Application for a non-material amendment following a grant of planning permission.

Resubmission of planning application relating to design amendments to planning permission 3/2017/0674 in connection with the construction of four dwellings including associated drives, gardens and external landscaping works

Reference number:	<input type="text" value="3/2018/0344"/>
Date of decision	<input type="text" value="24/05/2018"/>

5513 - P01E

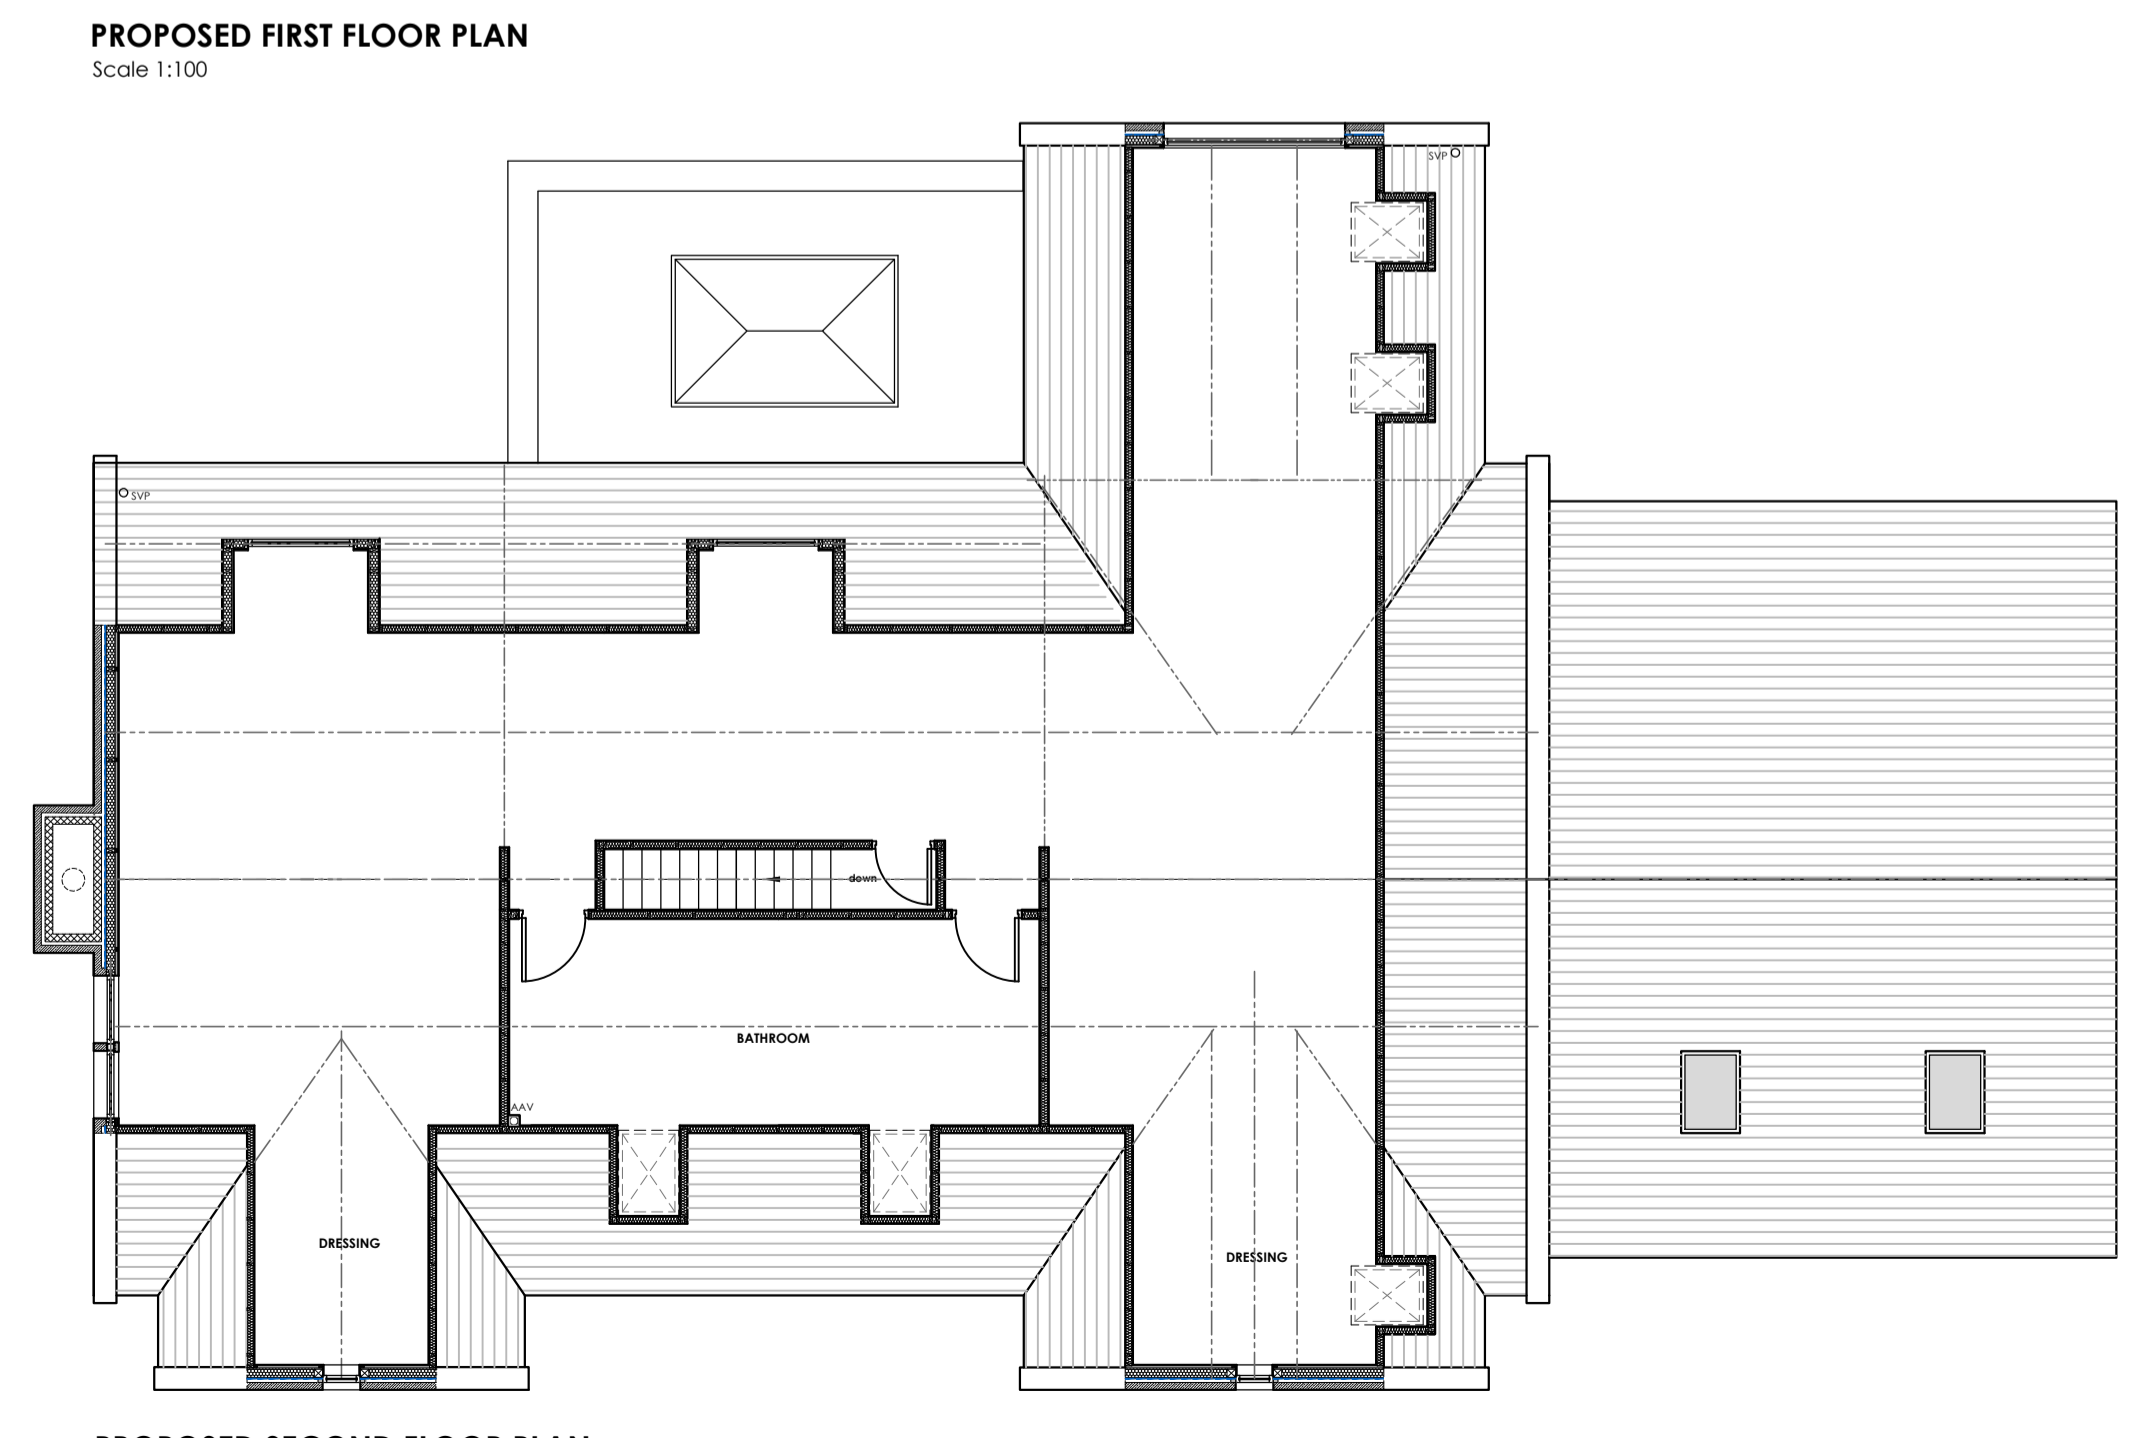
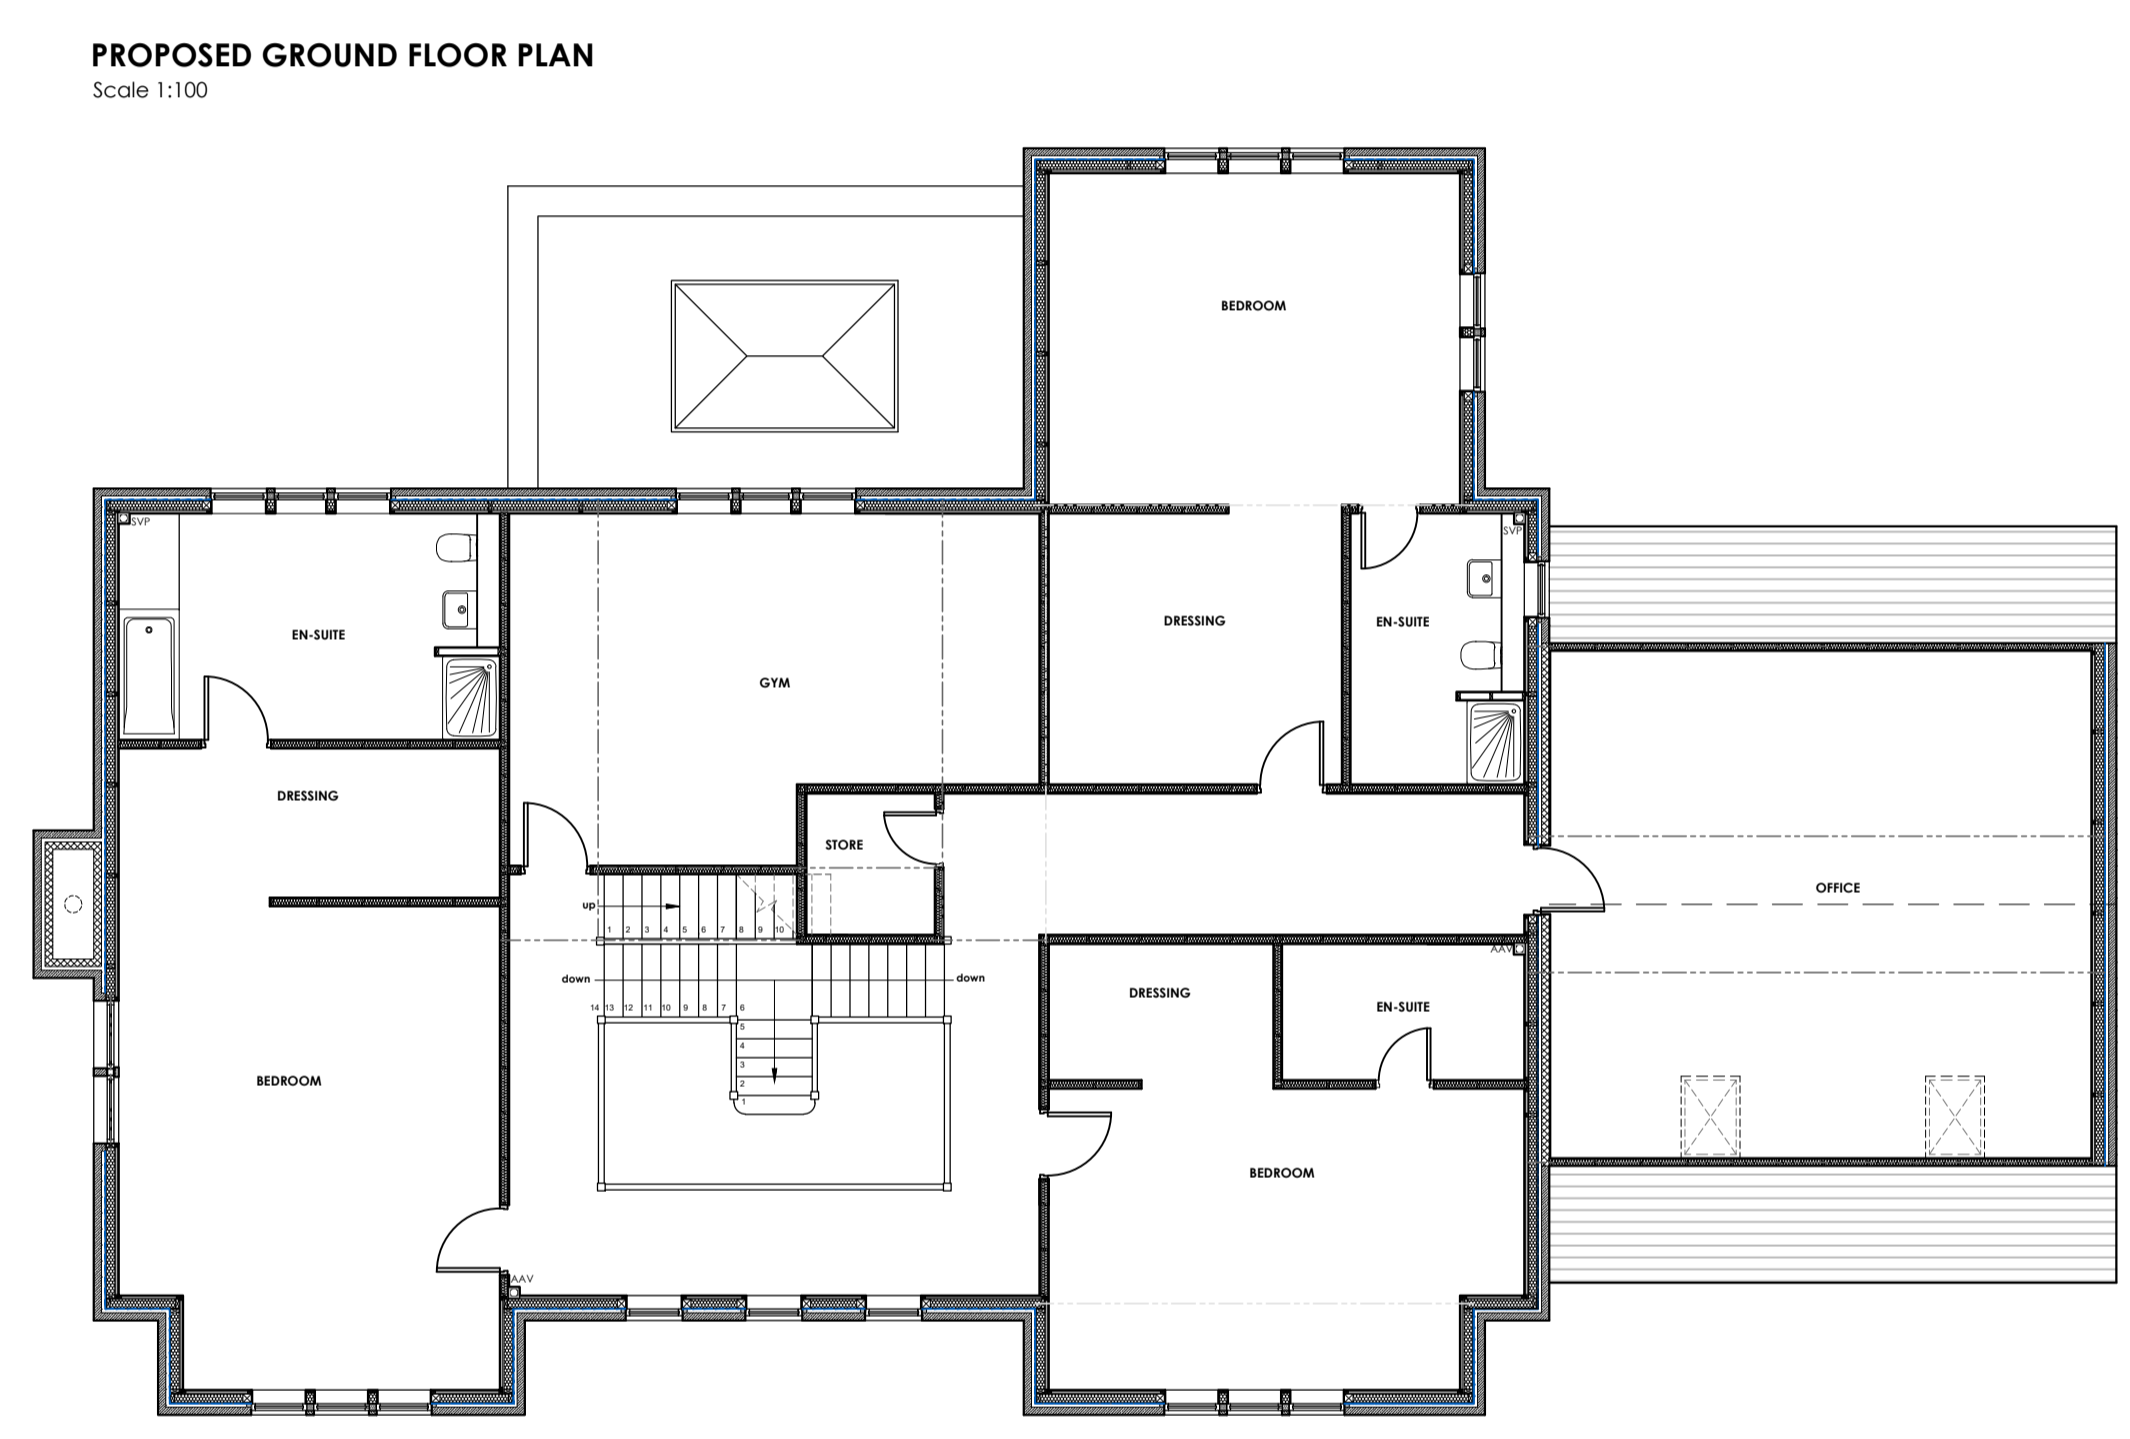
Plot 1: Window added to the east elevation, chimney altered, rooflight positions altered and garage roof height altered.
Plot 2: Central dormer added to the north elevation, chimney altered, rooflights added to the east and west elevation and rooflight positions altered.
Plot 3: Central dormer added to the north elevation, chimney altered and relocated to the east elevation, door relocated to the east elevation, rooflights added to the east and west elevations, rooflight positions altered, additional skylight added to the orangery and ground floor layout revised.
